From: Laura Gibbons <Laura.Gibbons@arun.gov.uk>
Sent: 24 August 2021 12:47
To: Planning.Responses <Planning.Responses@arun.gov.uk>
Cc: Brenda Louisy-Johnson <Brenda.Louisy-Johnson@arun.gov.uk>
Subject: RE: Planning Consultation on: P/49/21/RES

Further Engineers Comments On Surface Water Drainage

Application No: P/49/21/RES
Registered: 31st March 2021
Site Address: Land North of Sefter Road & 80 Rose Green Road Pagham
Grid Reference: 490199 99587
Category: Plan Applicat'n
Description of Works: Application for the approval of Reserved Matters pursuant to condition 1 (Reserved Matters details), condition 6 (Design Code Masterplan) & condition 7 (landscaping & layout details) following the grant of P/134/16/OUT for the erection of 250 No. dwellings, (including affordable homes), replacement scout hut, land for an Ambulance Community Response Post Facility, demolition of No. 80 Rose Green Road & provision of Public Open Spaces including associated children's play areas, landscaping, drainage & earthworks (resubmission following P/24/20/RES). This site also lies within the parish of Aldwick.

Land North of Sefter Road, Pagham - P/49/21/RES RM Application
Comment Tracker

Drawing Title: Surface Water Drainage Strategy Layout

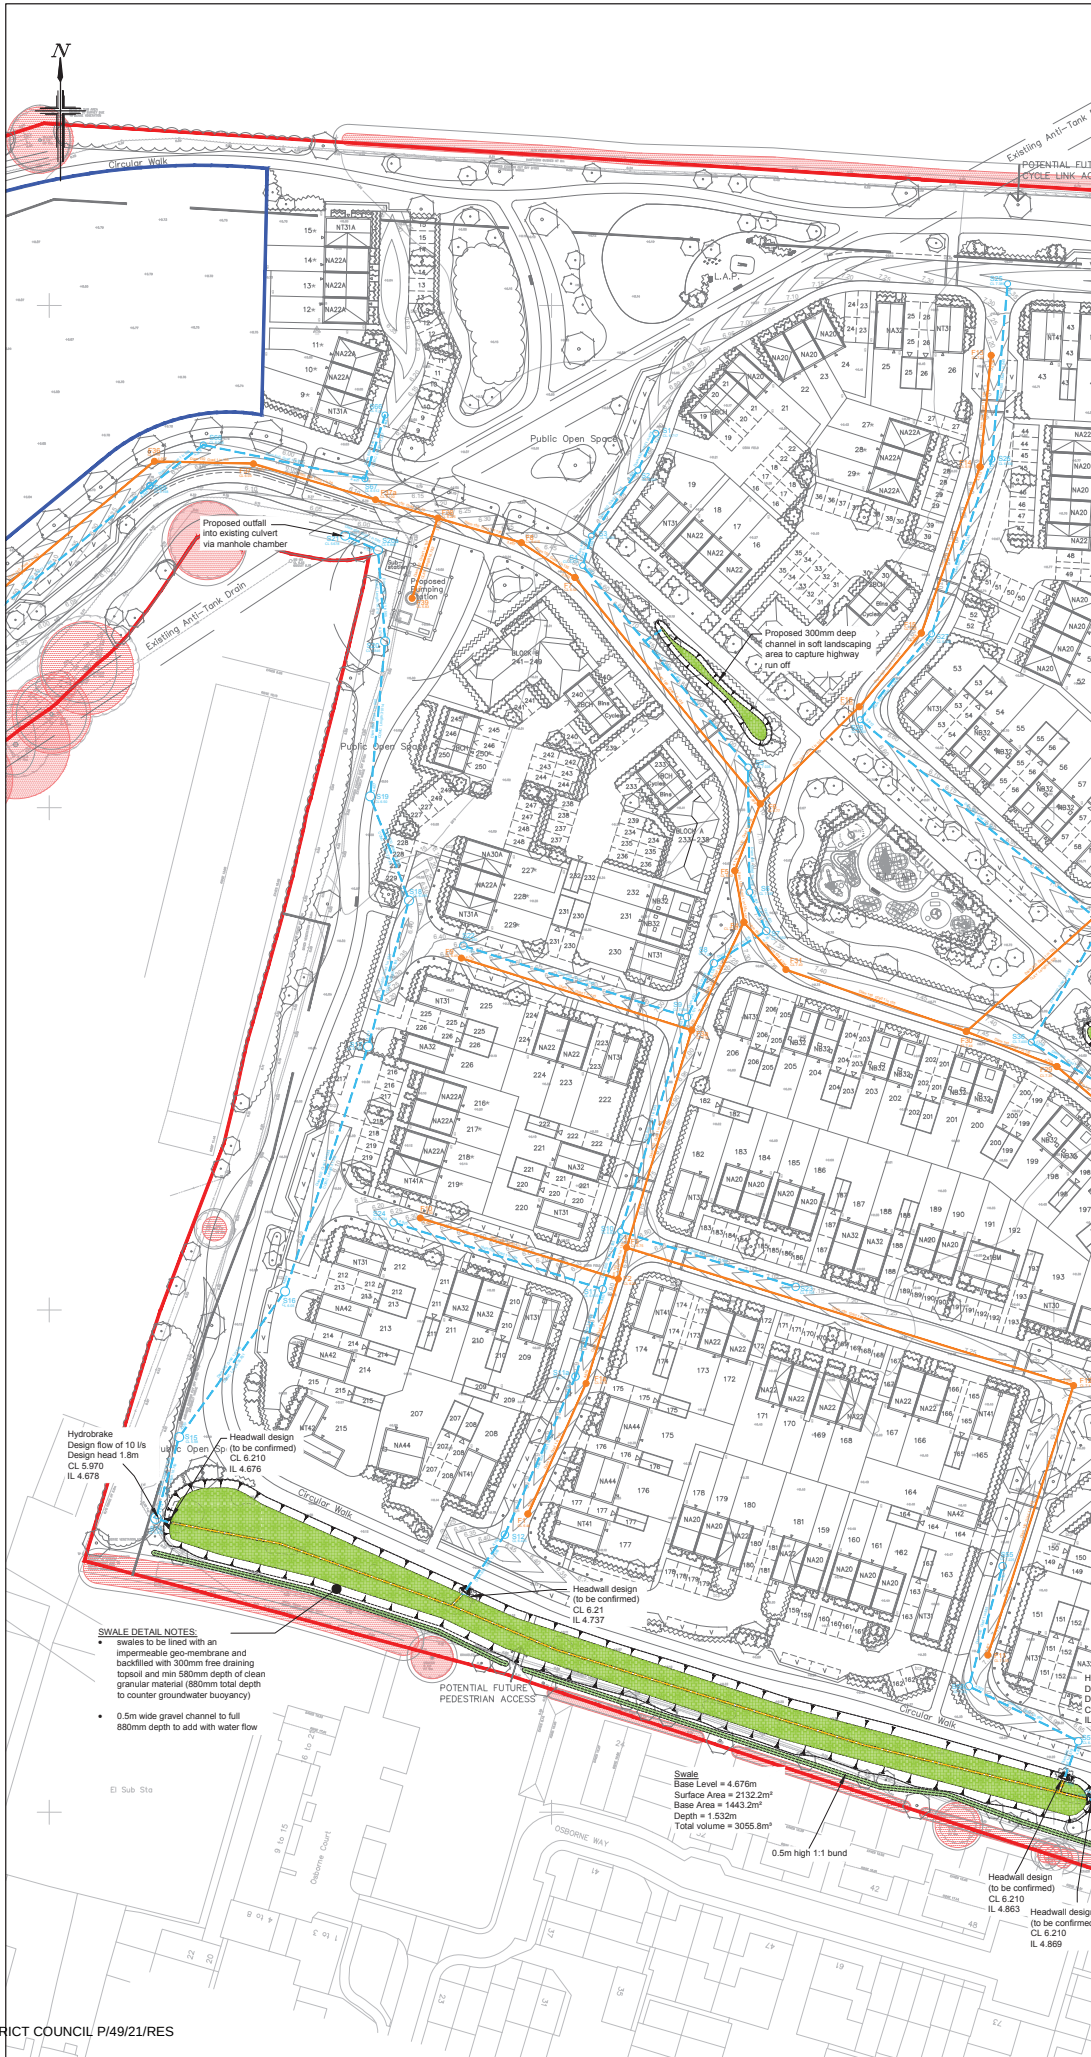
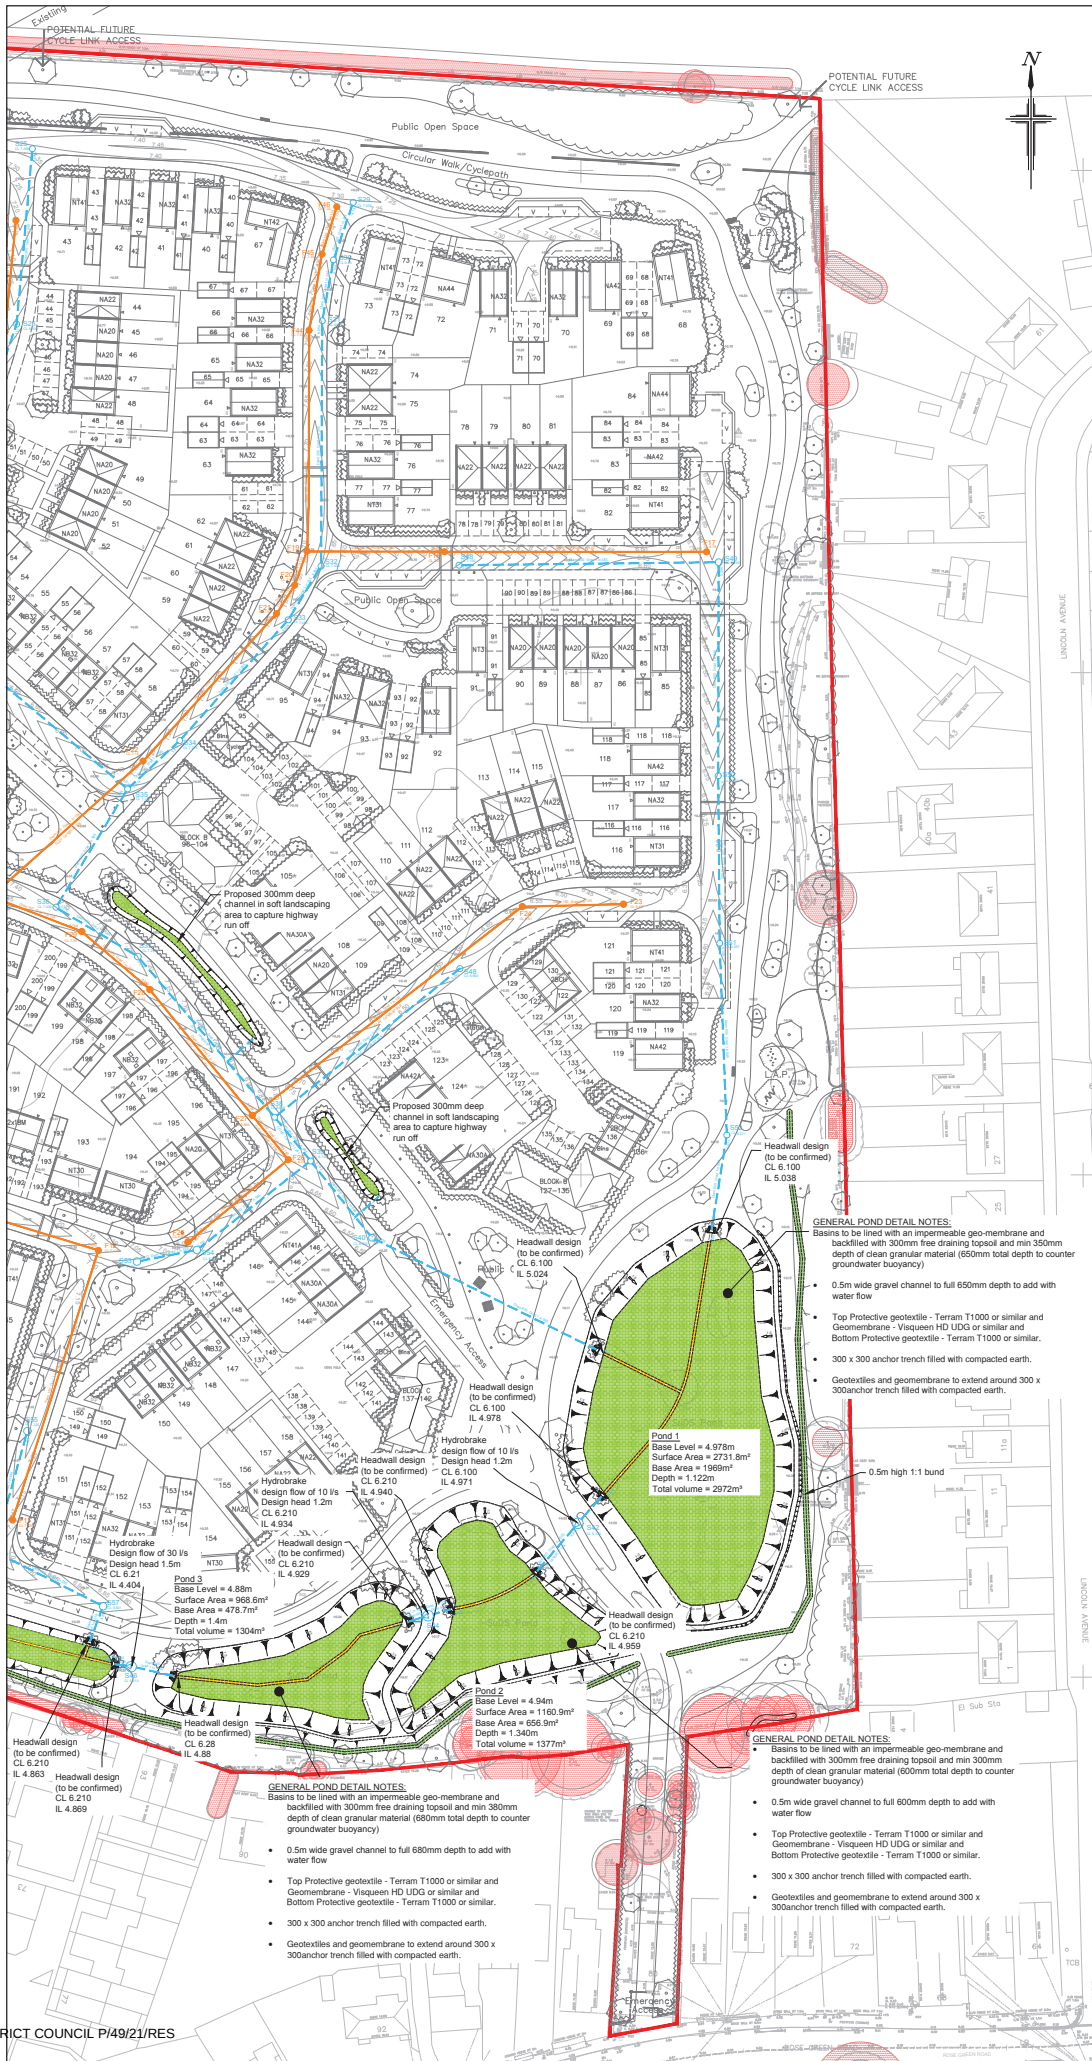
2	Please make it clear on plans where points of discharge are. The eastern network appears to have a discrepancy on the label for S46. The leader indicates an I.L of 4.4.04 but the actual network label indicates 4.872 which tallies with calcs. Without zooming in this does cause some confusion as it appears the network breaks its back based upon the leaders.	Noted this will be made clearer on the discharge of conditions submission (condition 10 – details of surface water drainage scheme pursuant to Outline planning permission ref. P/134/16/OUT).	This is required at this stage to evidence that the proposed layout includes sufficient room for surface water drainage.
3	Please provide two perpendicular cross sections per basin. These do not have to be construction detail level of detail but need to show basin dimensions.	Noted this will be provided with the discharge of conditions submission.	This is required at this stage to evidence that the proposed layout includes sufficient room for surface water drainage. Without this volumes provided cannot be independently verified.

8.	There are inconsistencies between calculations and the layout for; the attenuation tank at S80, pond at S75, pond at S79, please update.	Noted this will be made clearer on the discharge of conditions submission.	This should be resolved at this stage to evidence that the proposed layout includes sufficient room for surface water drainage.

11.	Where there is a gap in the bund for future connections, please detail whether the ground level here will be raised or not. We also wish to discuss the extent of this bund.	This is raised as per out discussions held on the 25/06/21.	Please show on plans.

12.	We note that the watercourse around pond 4 is proposed to be diverted, we are concerned by how little distance there is between the pond and watercourse.	This has been addressed in the updated layout, with the diverted watercourse offset further from the edge of the new SuDS basin to suit.	Please indicate available buffer between features

18.	A buffer plan showing a 3m buffer around the top of the bank of all basins and watercourses. There must be a minimum unobstructed width of 3m from the top of the bank of basins and watercourses to ensure that future maintenance can be completed.	This is raised as per out discussions had on the 25/06/21 and discussed that whilst a full 3m wide buffer couldn't be provided around the whole perimeter of each basin min 3m maintenance access was still provided along one side of each basin which provides a means for future maintenance.	Please show clearly on plans what buffers are being provided. We must see that the surface water drainage system and watercourses will be maintainable throughout the duration of development.

19.	A revised drainage strategy, updated to include the details requested above.	Updated strategy plan provided.	See above comments.
20.	A plan which clearly shows proposed changes in ground levels.	Level strategy plan provides this level of information.	Please provide.
